Planning and Development Acts 2000 to 2018

Planning Authority: Cork County Council

Planning Register Reference Number: D/310/18

WHEREAS questions have arisen as to whether:

(D) PERGOLA

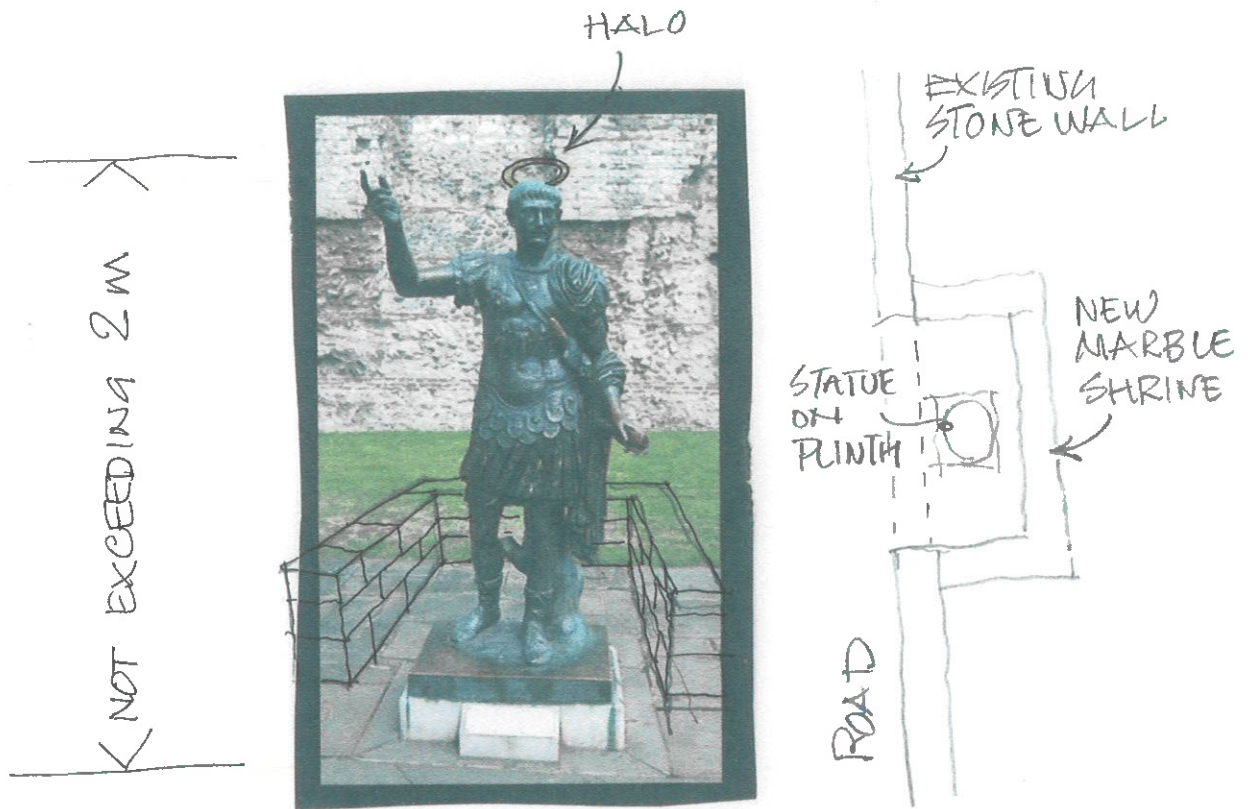
- (a) the retention of a 55 square metres pergola would constitute development, as it involves works and there are no provisions of exempted development that would apply to the works,

- (a) a pergola on a paved area as part of an ornamental garden,
- (b) painted lettering advertisement on the roof,
- (c) the erection of a statue of 'Liam Madden', and
- (d) a private paved area, the demolition of an existing boundary wall and the construction of a stone wall not exceeding 1.2 metres in height,

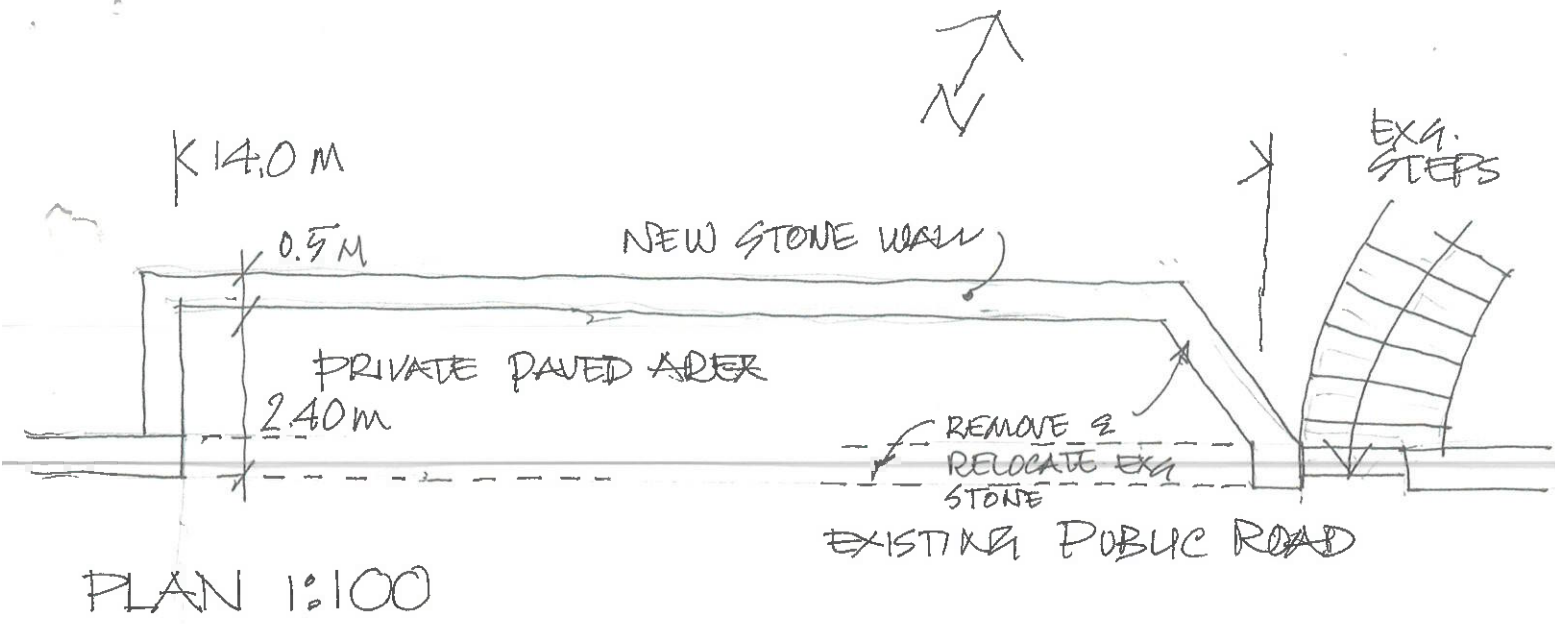
- (b) the painted advertising lettering comprising 'Man Friday' on the roof slope does not fall within the scope of Class 1 of Part 2 of Schedule 2 of the Planning and Development Regulations, 2001, as amended, as it does not comply with Conditions and Limitations numbers 2 and 8 of Column 2 of Class 1 with regard to the overall area and height of the advertising and height of the individual lettering in the advertising and is, therefore, not exempted development,

- (c) the erection of a statue, as proposed, does not fall within the scope of Class 33(b) of Part 1 of Schedule 2 of the Planning and Development Regulations, 2001, as amended, and is, therefore, not exempted development, and
